**WELWYN HATFIELD COUNCIL – DEVELOPMENT CONTROL  
DELEGATED REPORT**

<b>APPLICATION No:</b>	<b>S6/2011/0243FP</b>
------------------------	-----------------------

**DESCRIPTION OF PROPOSAL:**

PROPOSED GROUND FLOOR PLAN

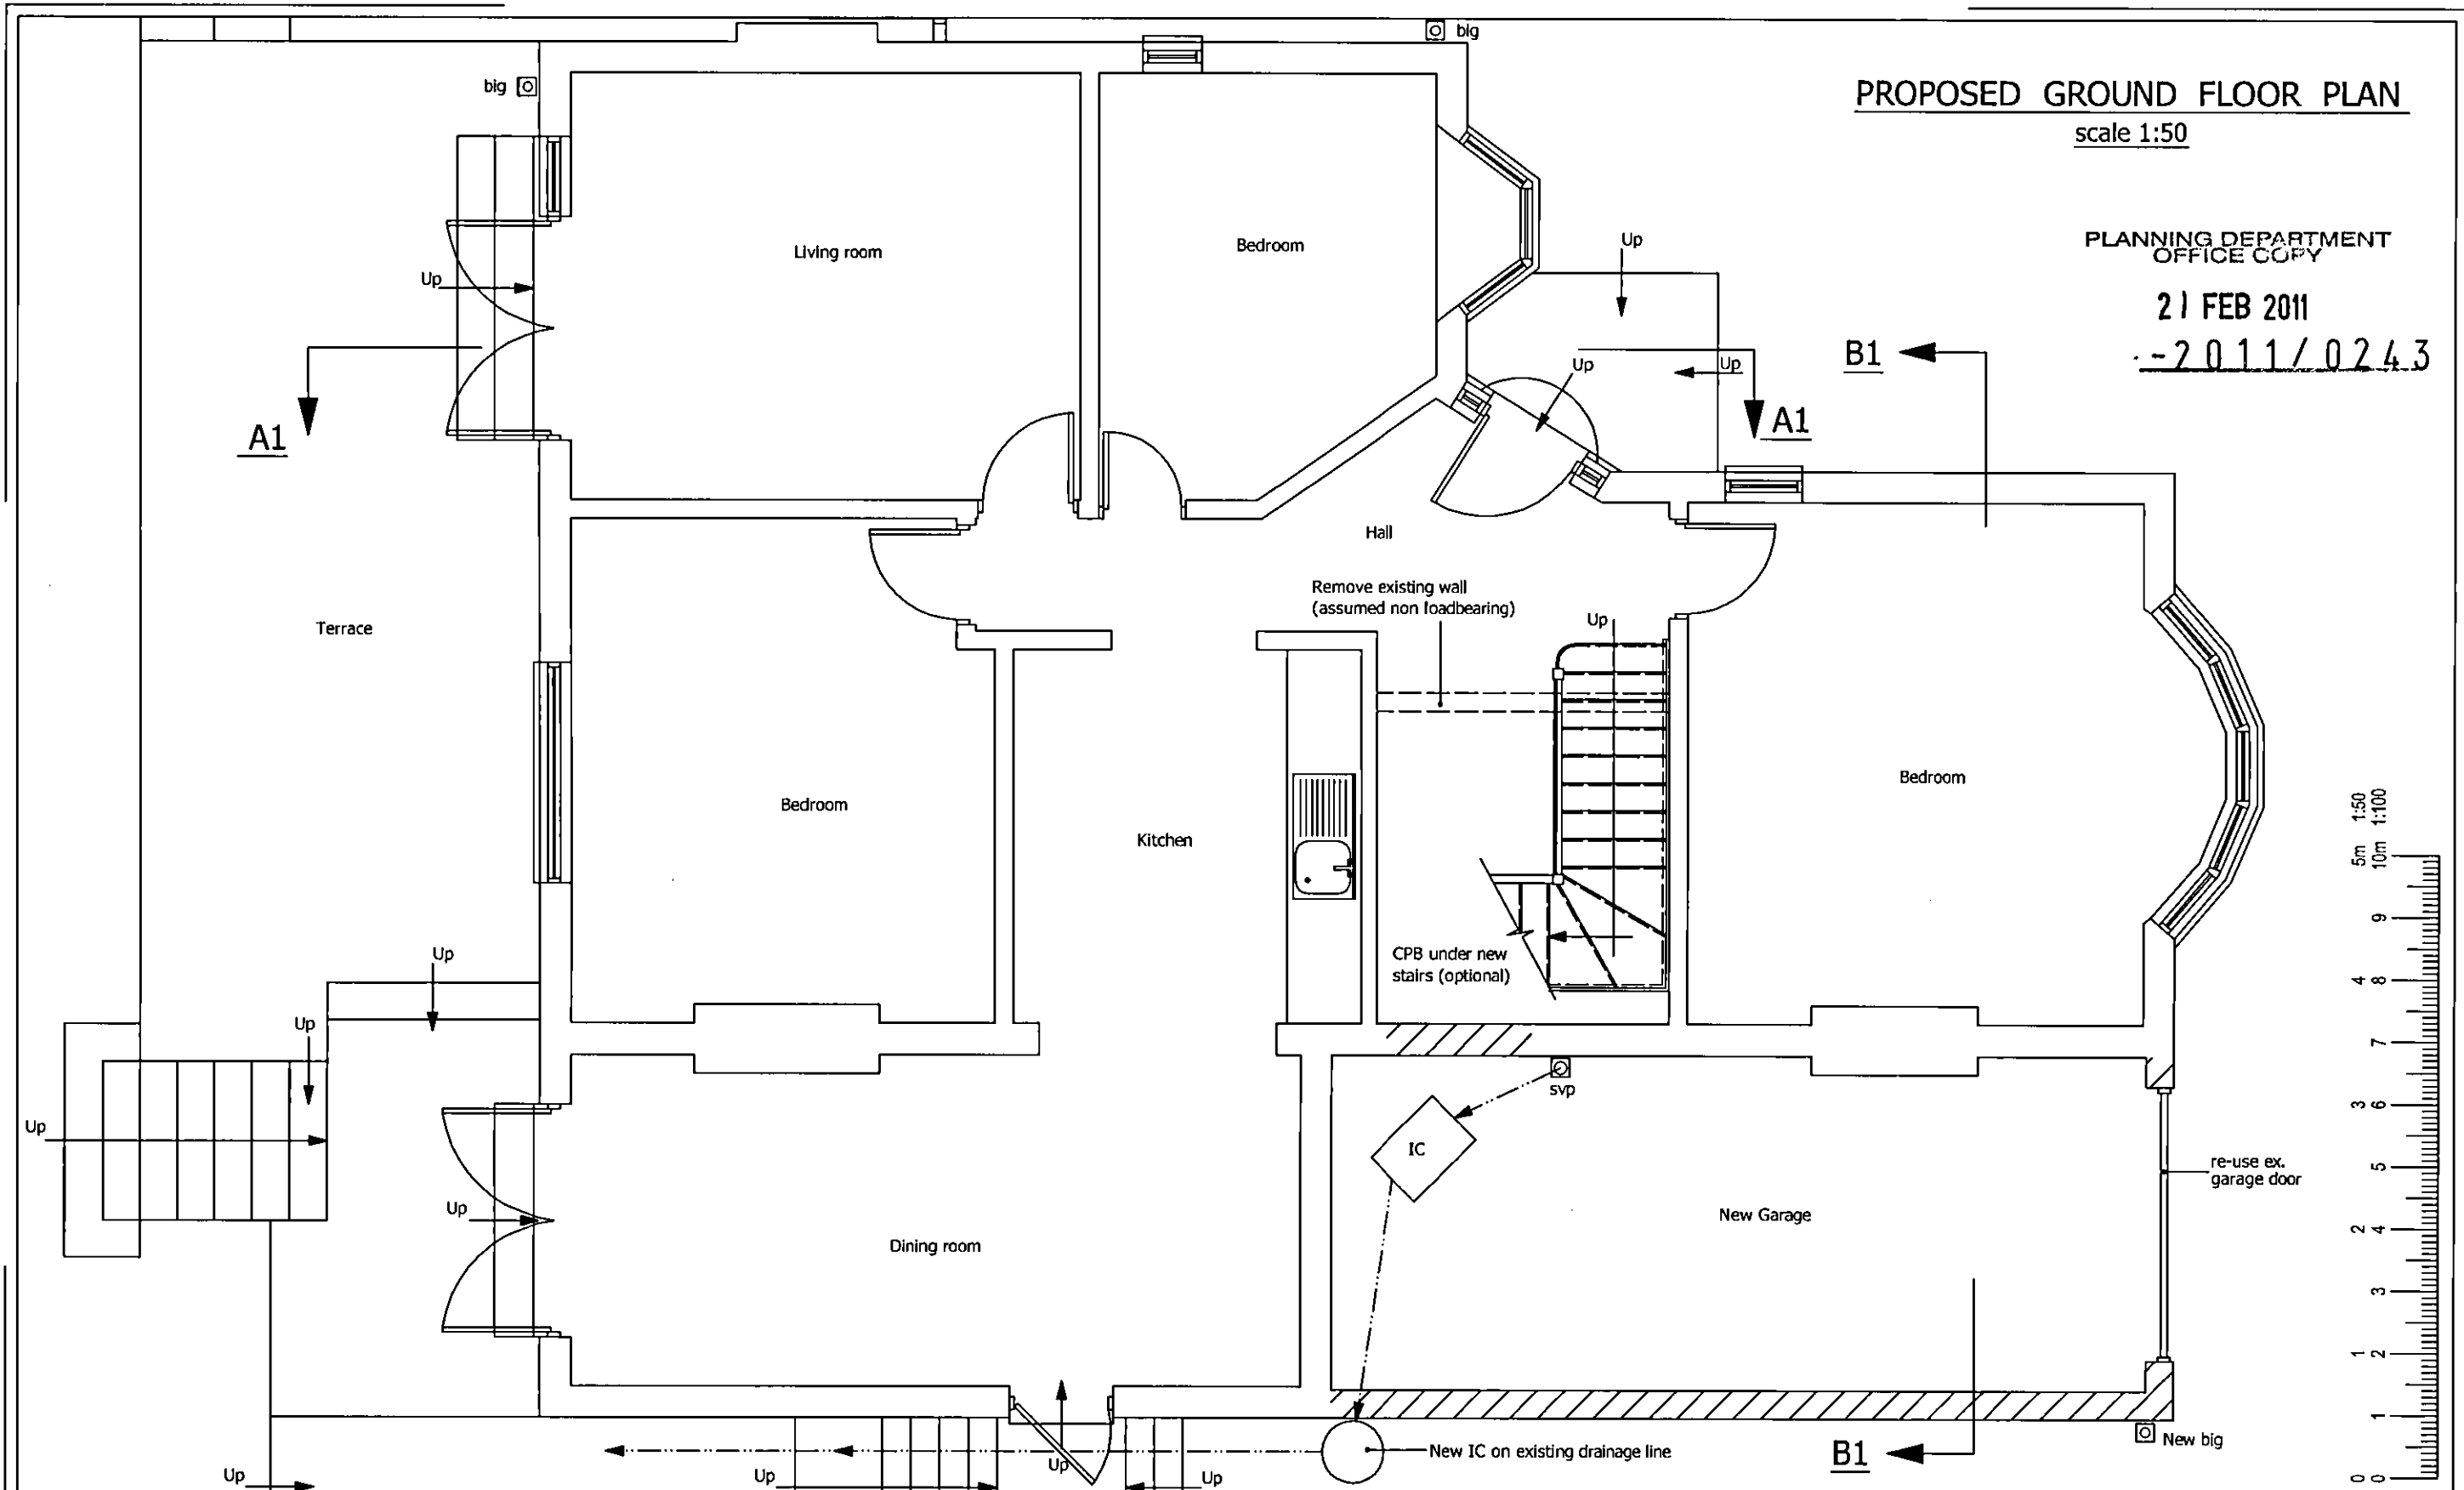
The proposed development would involve the removal of an original detached garage and rebuilding this as an integral single detached garage in a similar position at a slightly larger size.

A visual assessment is also relevant as part of this assessment. The proposals would not significantly increase the size of the ground floor area or the footprint of the building as the existing garage is to be demolished and replaced. The concerns are therefore only with the proposed changes at the new first floor level.

The impact on this neighbour from the proposed ground floor extension would be very limited as it would replace an existing garage.
